From: Gregg, Robert <Robert.Gregg@lancashire.gov.uk>
Sent: 17 August 2018 14:24
To: Adam Birkett
Cc: planning
Subject: APP. 3/2018/0459 - THE OLD RESERVOIR, SABDEN

PLANS: ELEVATIONS SECTION as PROPOSED

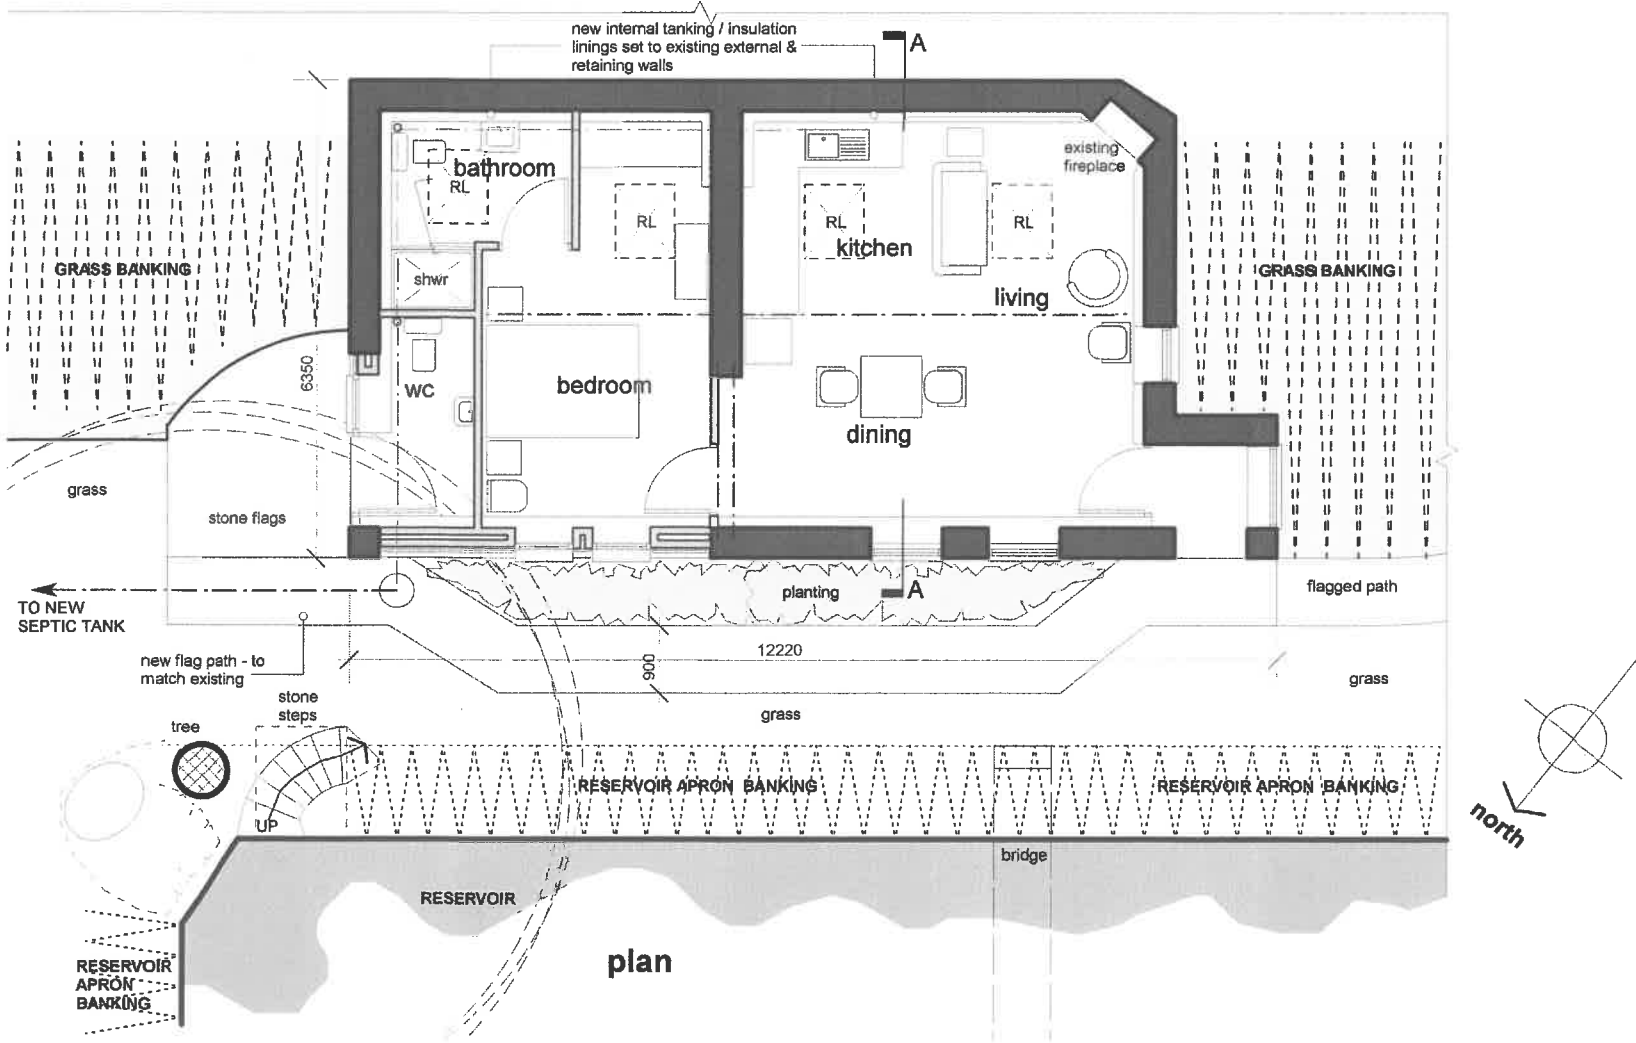
The proposal for the conversion of the existing agricultural buildings to form a holiday let indicates from the submitted plans that the holiday let will consist of one bedroom. It also states that the proposal will accommodate for the arrangement of 3 - 4 parking spaces, Although there has been no submitted plans to indicate how this can be achieved nor the justification as to why the provision of 3 - 4 parking spaces would sufficiently comply with the maximum parking standards. I would need to see clarification in the form of a scaled plan which would detail the layout of the parking area, The formation of the proposed parking arrangements along with how manoeuvrability will also be achieved so that any vehicles that would be entering or leaving the access point would be able to do so in forward gear, I would like to see the visibility splay also being detailed into this layout.
